Freedom Forever
Planset Revision Letter

7/28/2023
REV #1

AMANDA TURLINGTON
595 MCLAMB ROAD , COATS, NC 27521

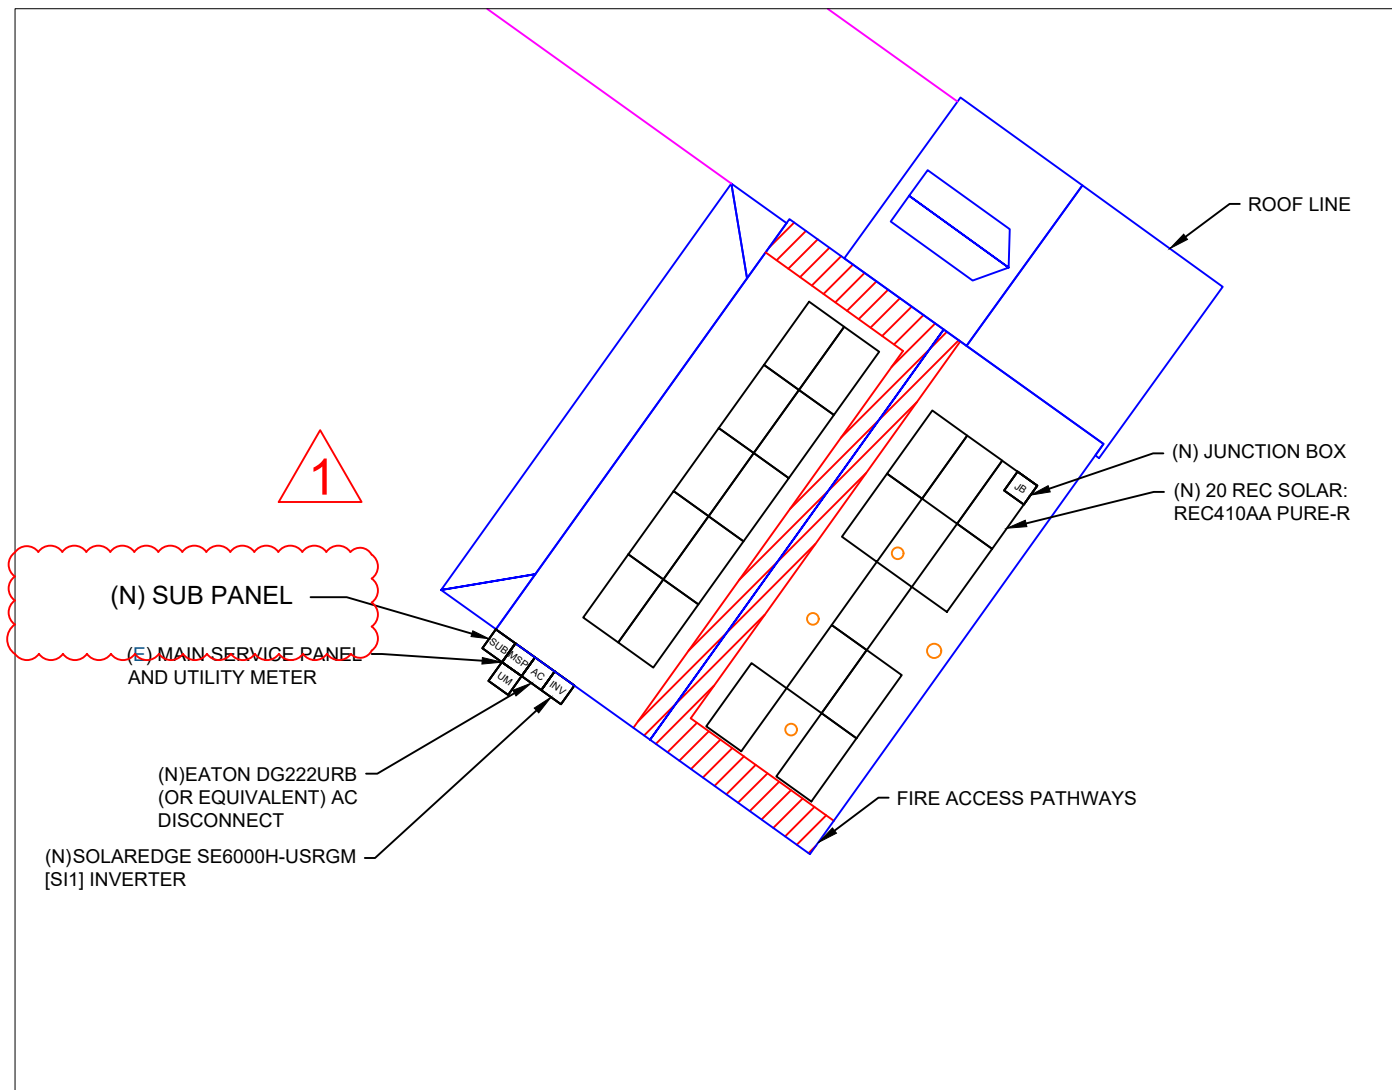
Sub panel added to site plan and ELD corrected
